Recommendation Report for Planning Permission for Works or Extension to a Dwelling

REF NO: BN/23/19/HH

LOCATION: Cox's Farm
Lake Lane
Barnham
PO22 0AJ

PROPOSAL: Two storey side extension.

DATE	DRAWN	SCALE	NUMBER
APRIL 2019	W	1:100	1828.08

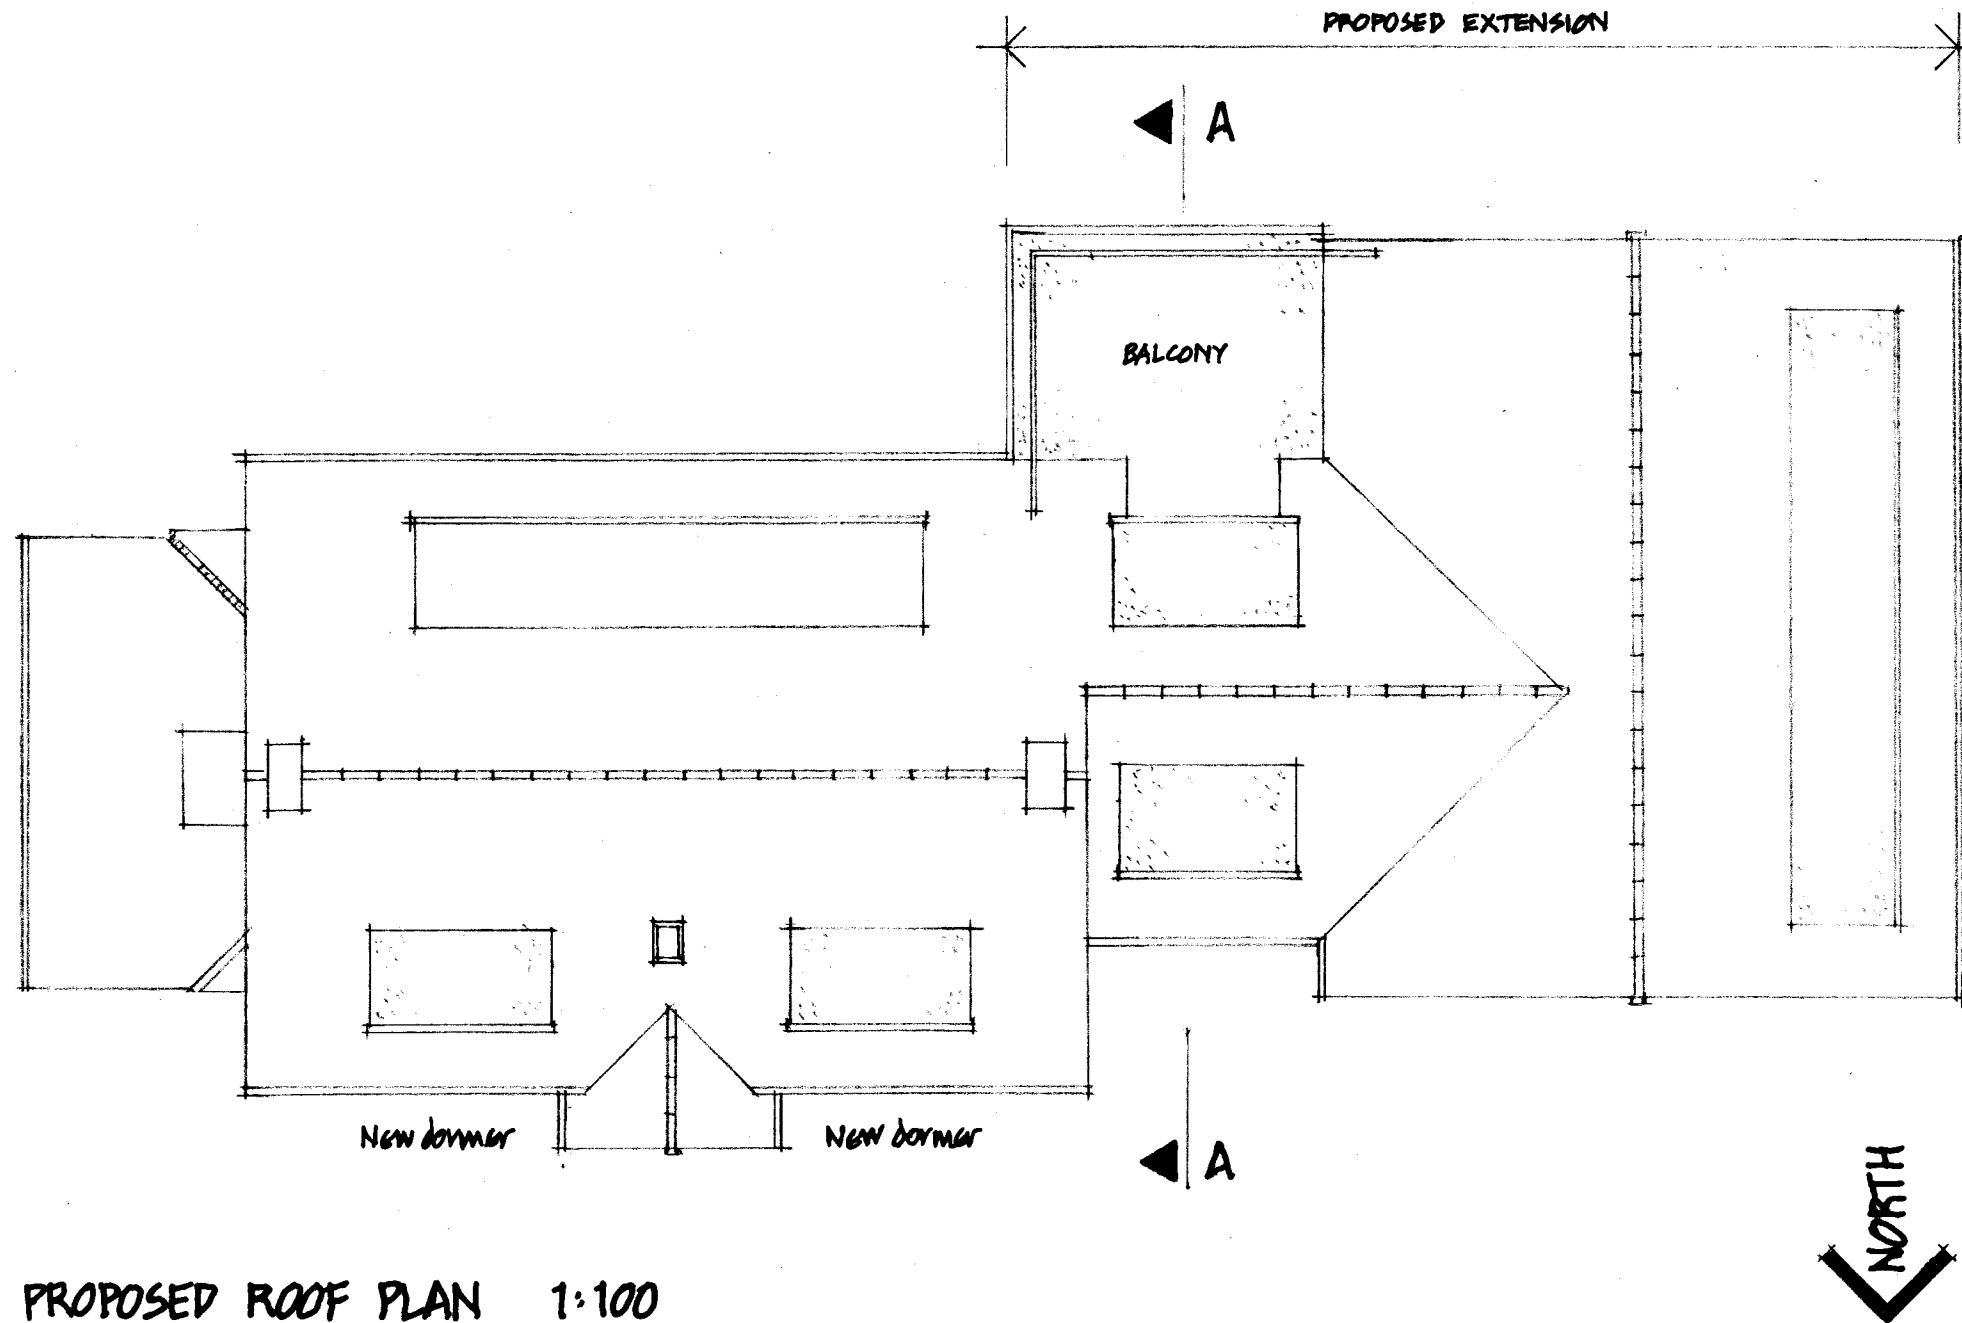
There will also be new dormer windows to the existing dwelling. These are modest in size and appear well integrated.
